## Portishead Branch Line (MetroWest Phase 1)

**Planning Inspectorate Reference: TR040011**

**9.57 ExA.CAS.D6.V1 – Applicant's response to Additional Submission of Andrea Gordon (AS-067)**

**Date: March 2021**

Drawing **PILL TUNNEL EASTERN PORTAL COMPOUND LANDSCAPING & ACCESS PLAN SHEET 1 OF 2**

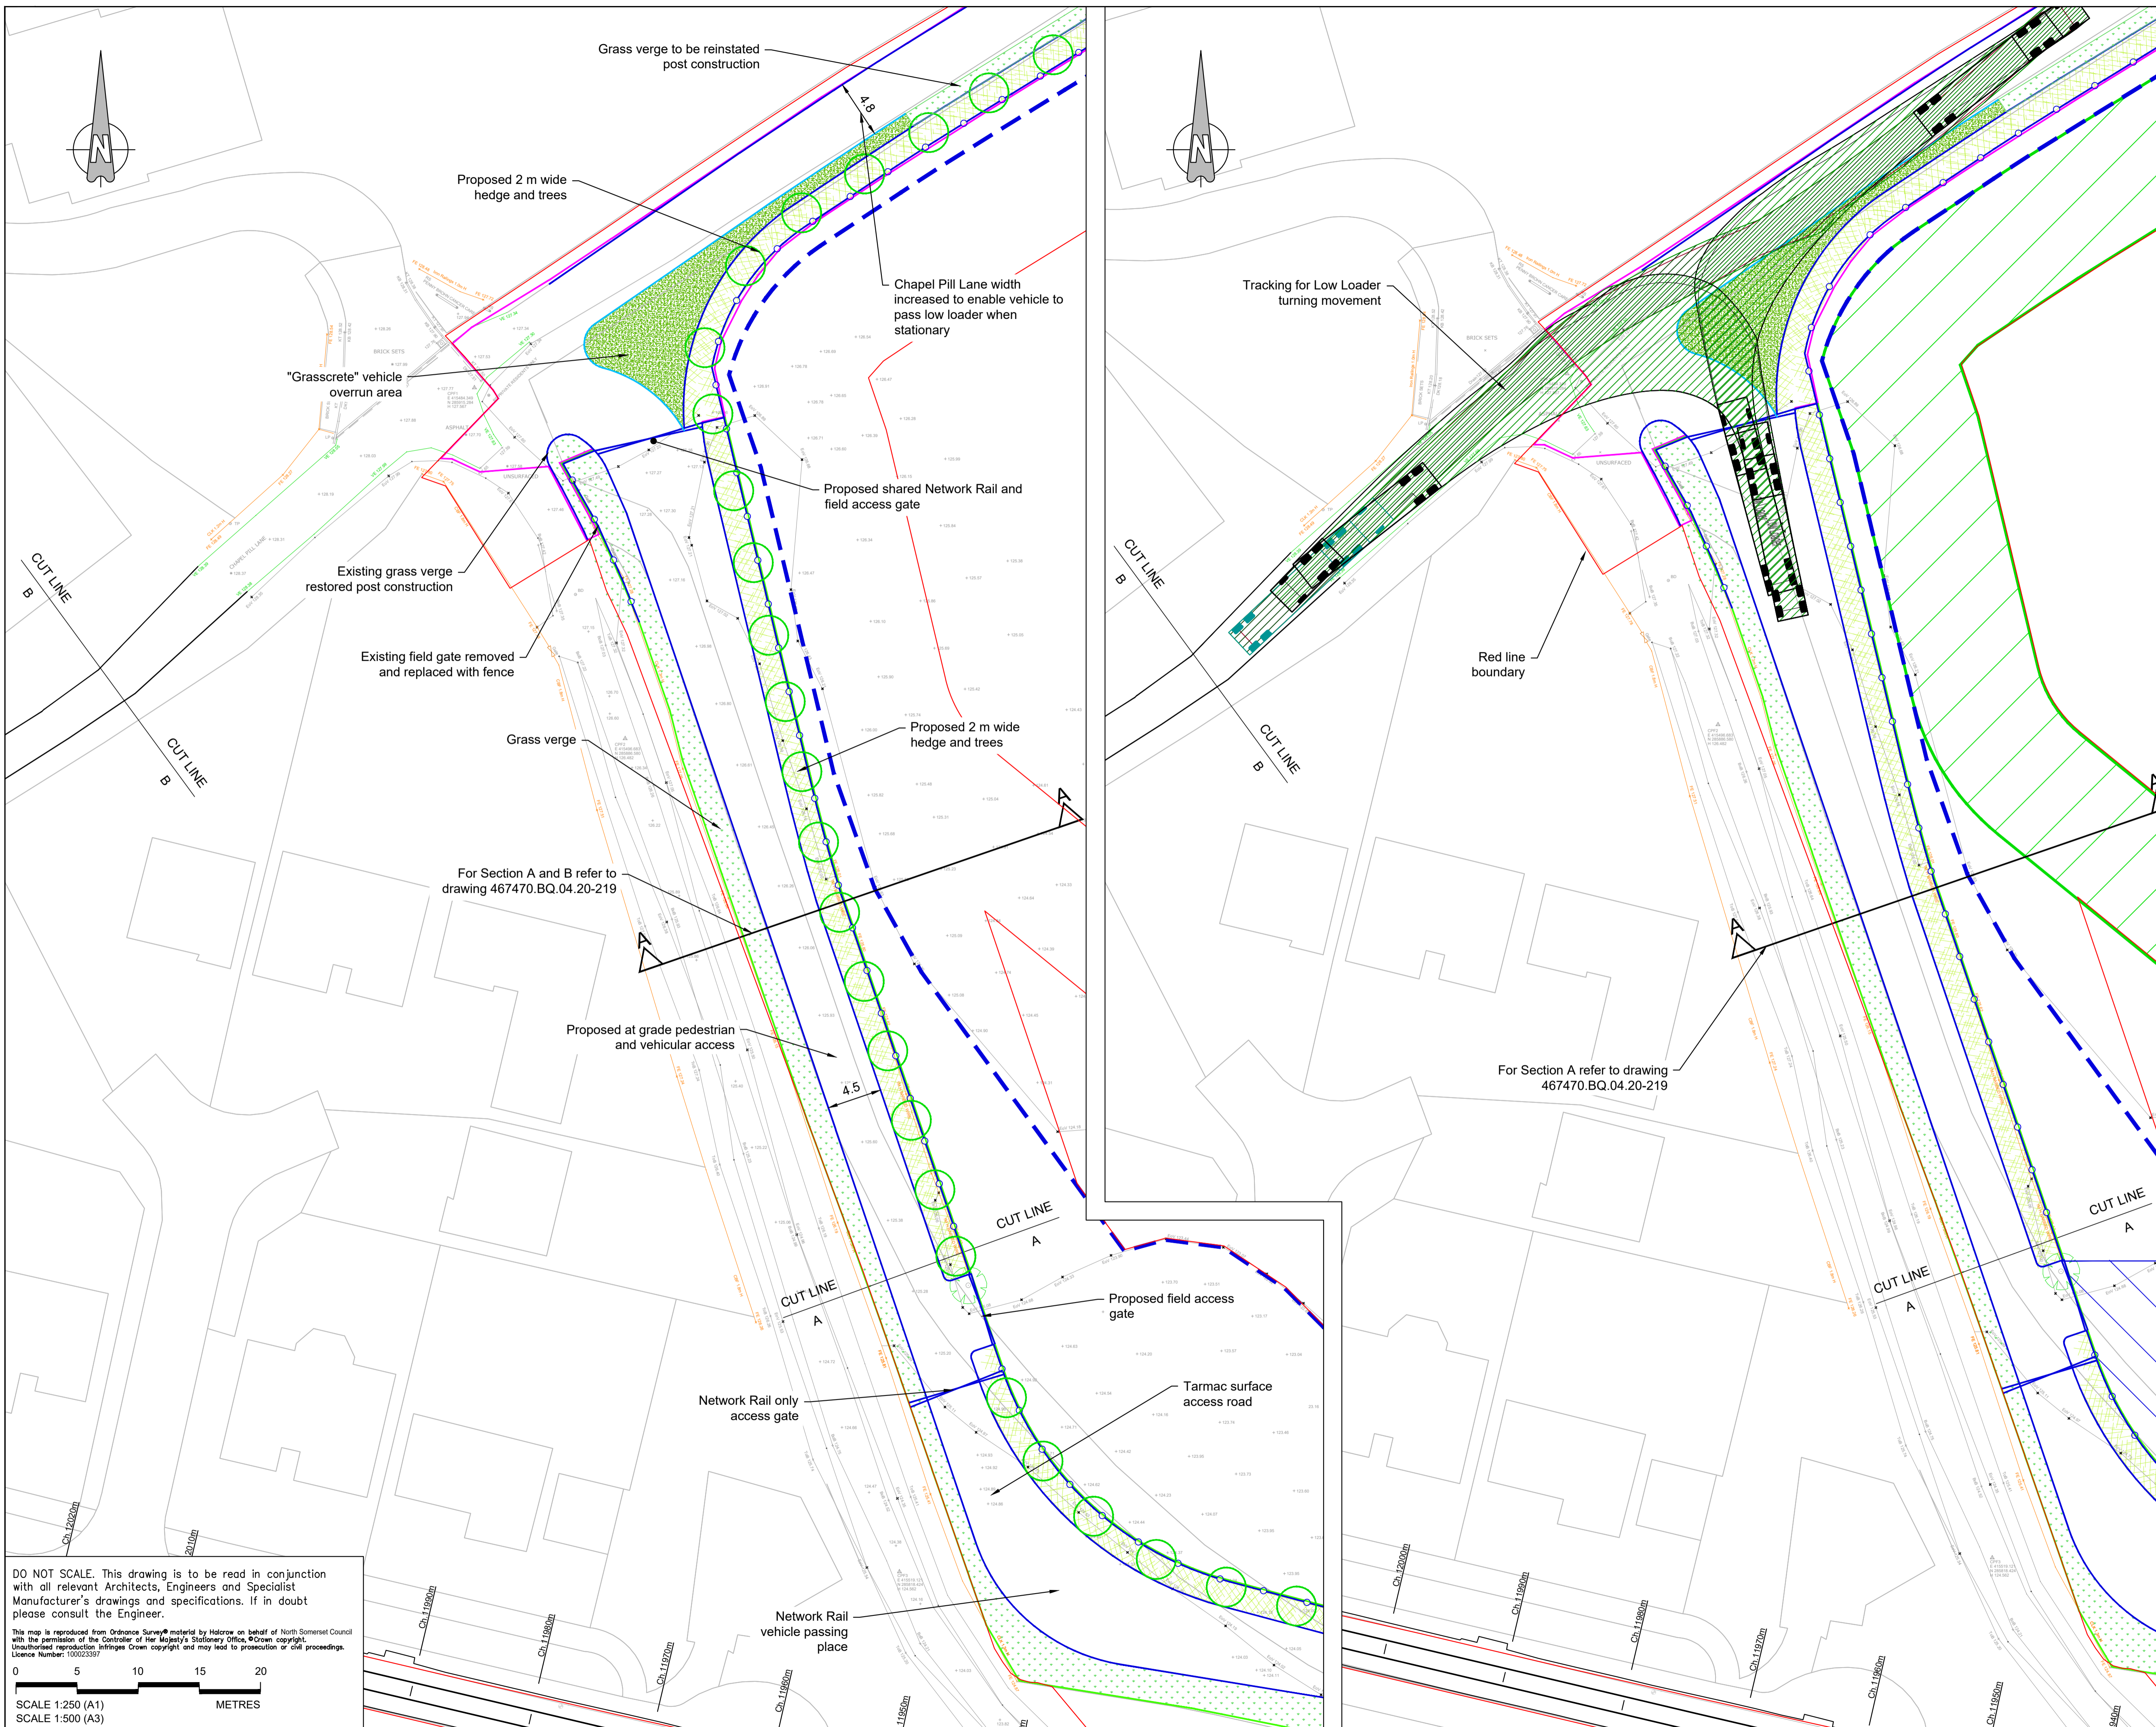
5. *The width of Hayes Mayes Lane is not sufficient to accommodate HGV's. Hedgerows and mature trees are in close proximity on both sides. It would therefore be necessary to remove the hedgerow and trees along one side to accommodate HGV's. This would be disruptive to the residents of Hart Close and would have adverse impacts on the landscape and ecology of the area. The alignment that we selected in late 2015 and consulted on in 2017 does not entail extensive removal of vegetation other than a small section of hedgerow at the northern end of Hayes Mays Lane and Chapel Pill Lane, in order to widen the access into the field to re-instate the former track down to the railway used in 2001.*

Given that maintenance vehicles, and emergency services vehicles will need to access the compound safely and in all weather conditions ~~on a permanent basis~~ and given the compound is at the bottom of a gradient, it is necessary for the access track to have a sealed tarmac surface, to ensure these vehicles can safely traverse the gradient. We also explained in our response of 1<sup>st</sup> March that:

*In respect of grasscrete, this is not a suitable material for the track because of the gradient of the field would cause the wheels of vehicles to spin particularly in wet whether traveling up the gradient.*
